## **FIRE RISK MANAGEMENT, INC**

# **Memo Report**

**Subject: Fire Safety Evaluation of Residential Property Located at 39 Cumberland Ave.,  
Portland, ME**

A1 1/4"=1'-0" BASEMENT PLAN

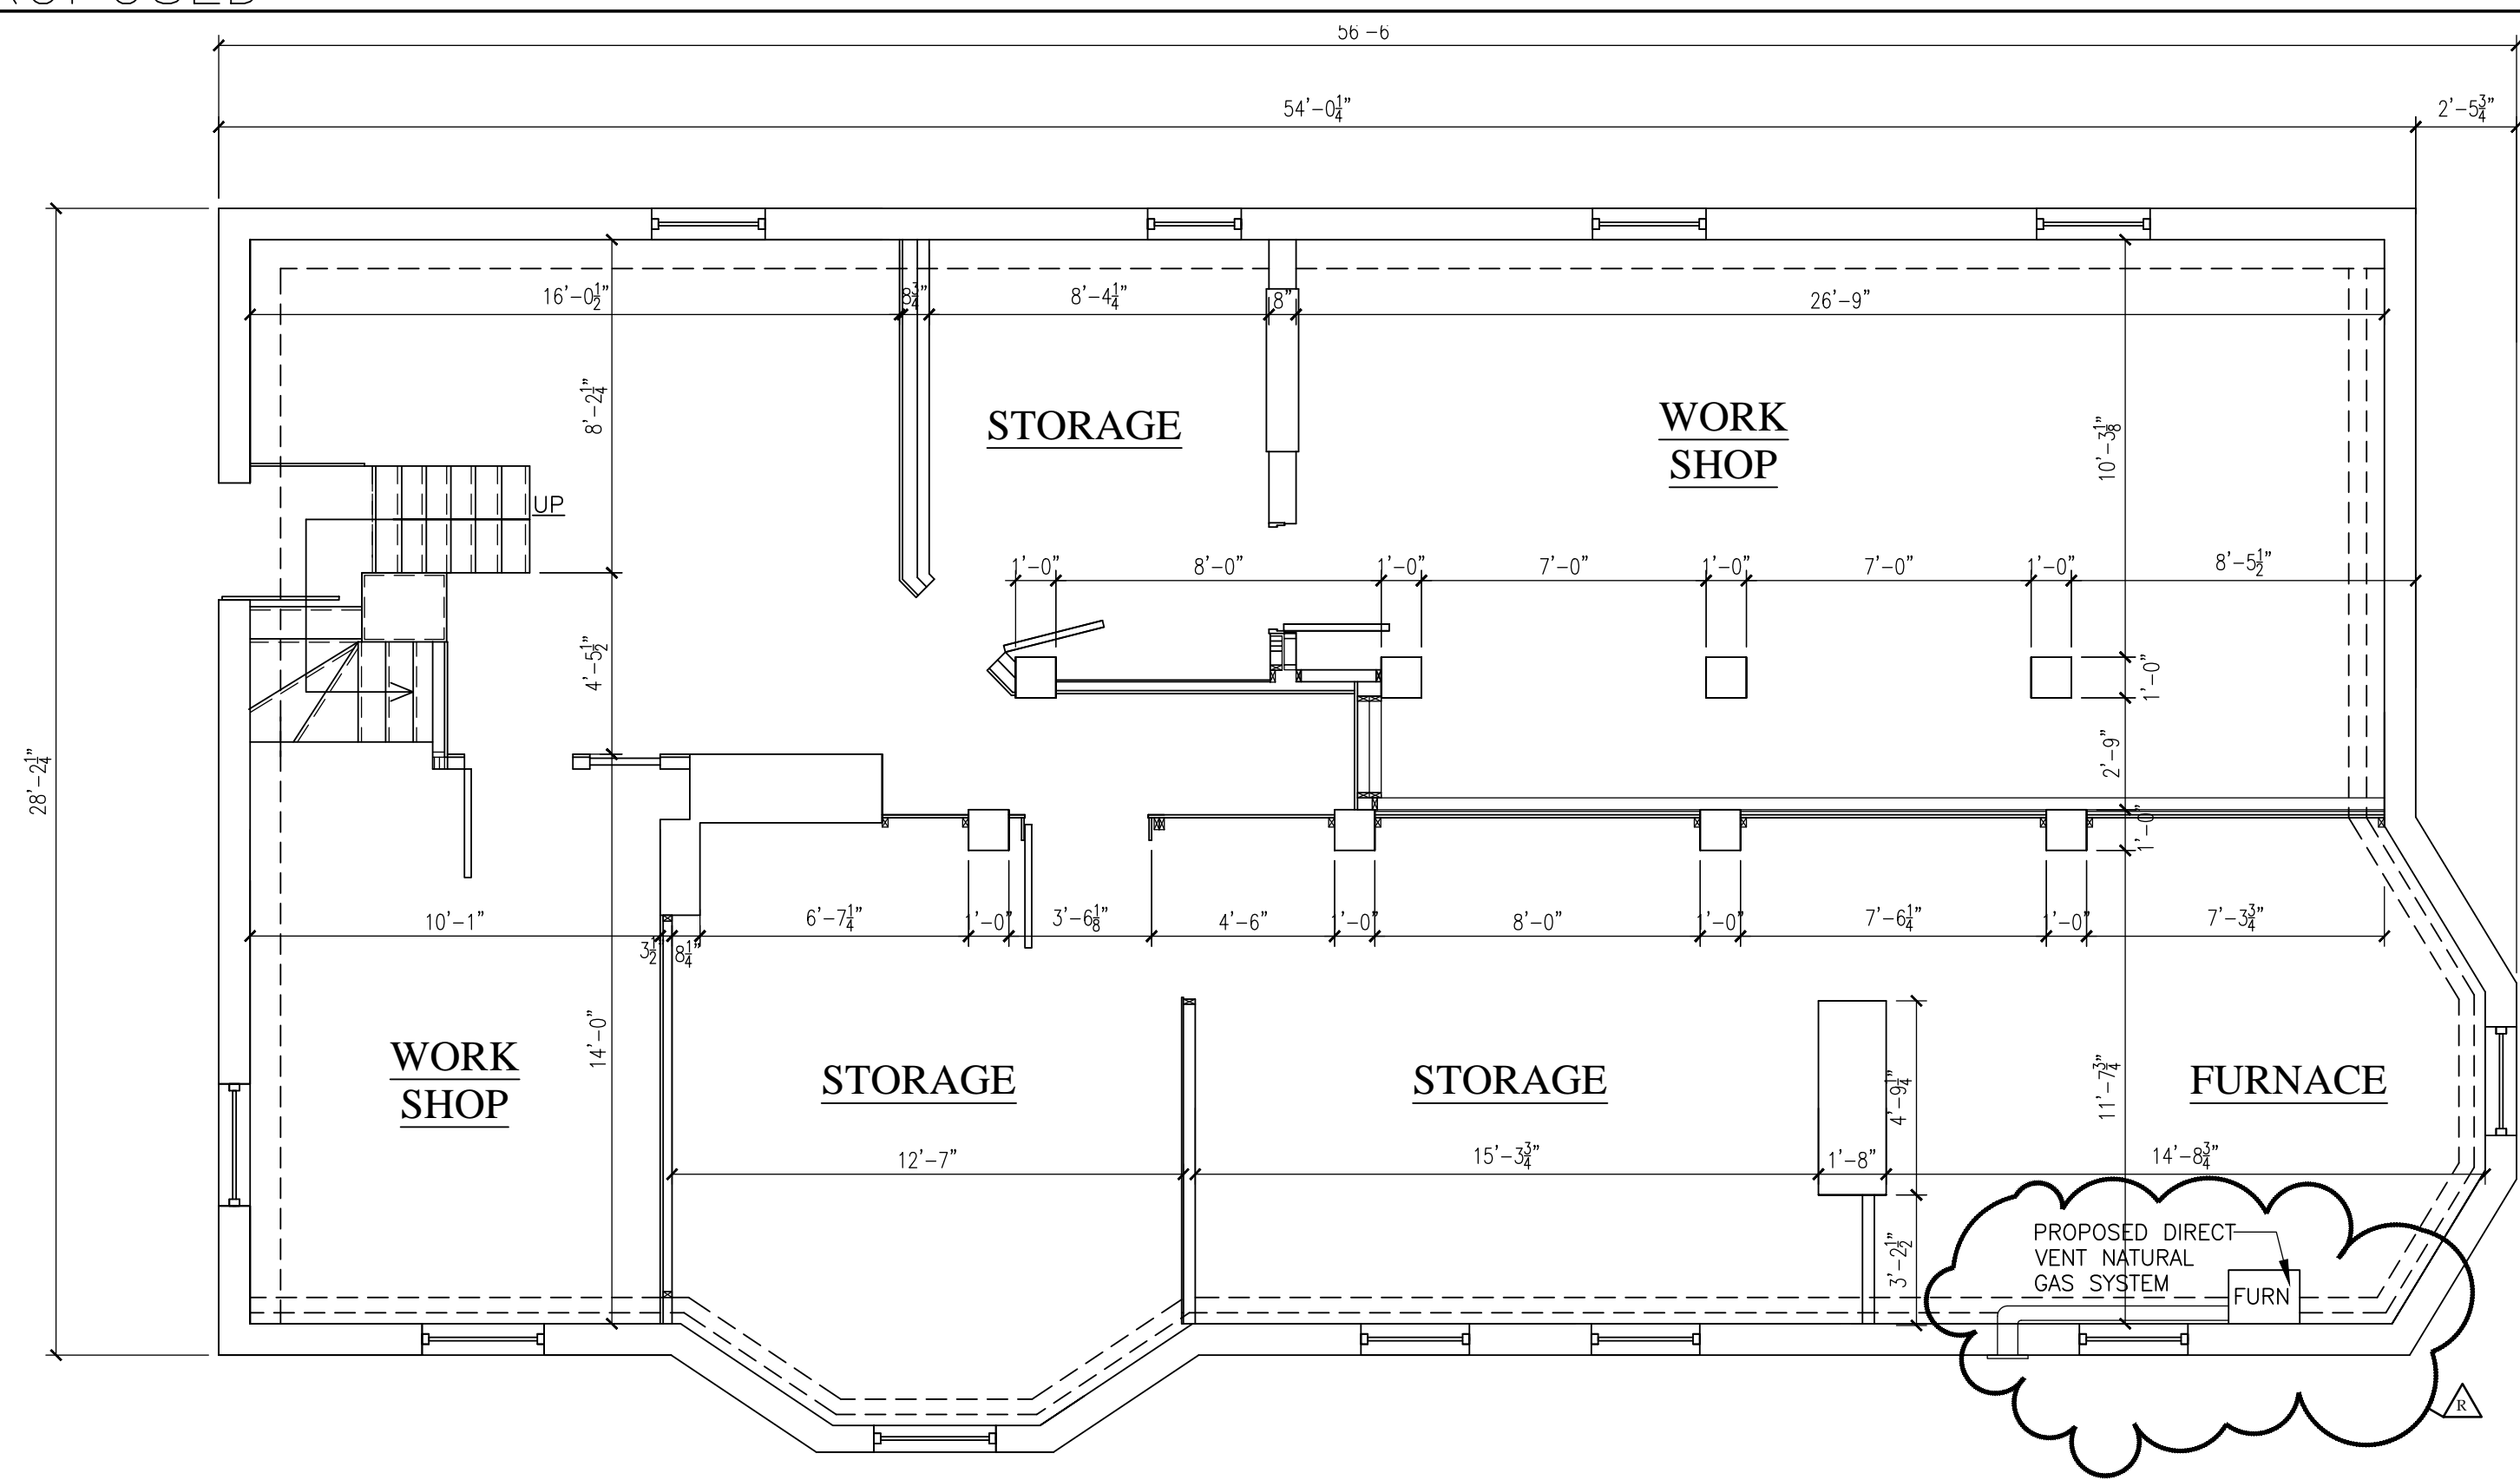
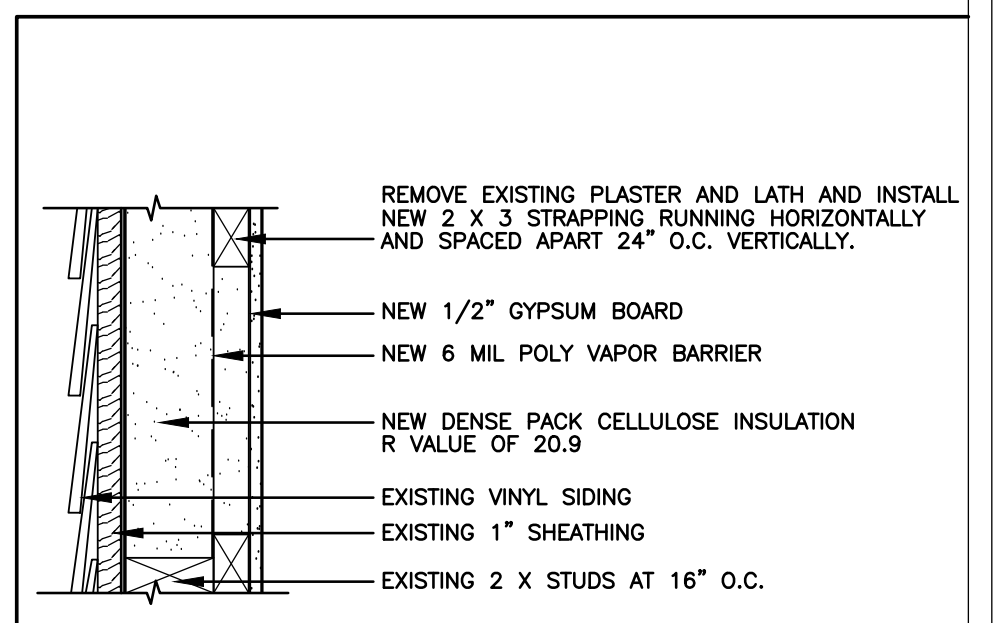
Questions have been raised regarding both the fire separation and egress requirements for the basement area of the building. It was stated that the City officials indicated that a 2-hour fire separation should be provided between the basement and the rest of the building. Based on the code requirements that we believe to be applicable, only a 1-hour fire separation would be necessary for the floor/ceiling assembly that separates the basement and 1<sup>st</sup> floor. Given the fact that the existing assembly consists of heavy timber construction, the 1-hour requirement would have been met by the inherent construction of the building; albeit any penetrations through this assembly would still need to be properly sealed. We see no justification for the addition of a fire-rated drywall ceiling. The codes do require that the "furnace room" be separated from the rest of the building with 1-hour fire-rated barriers. In this instance, this would require that the portion of the basement that is to be designated as the furnace room be provided with rated walls and doorway to separate this room from the rest of the building. Depending on the desires of the owner, this could be accomplished by simply adding a new doorway, or wall and doorway, at one of the existing locations where it is possible to make use of the basements existing configuration to minimize the need for additional construction.

1. The furnace room in the basement will need to be isolated from the rest of the building. As discussed during the site survey, there are a number of options available to accomplish this. Once this area is isolated, it will also be necessary to install a CO detector within this room. No other modifications to the basement area are necessary to meet code requirements.
2. Automatic closing devices should be provided on all doors that open to the rear stairway.
3. As a result of the sound-proofing that is associated with the room in the basement that is used for practicing musical instruments, it is recommended that a smoke detector, or other notification device, be installed within this room that is also connected to the smoke detector(s) in the other

- ① ~~No~~ No second means of ~~escape~~ escape from basement.
- ② This is by definition a "living area"
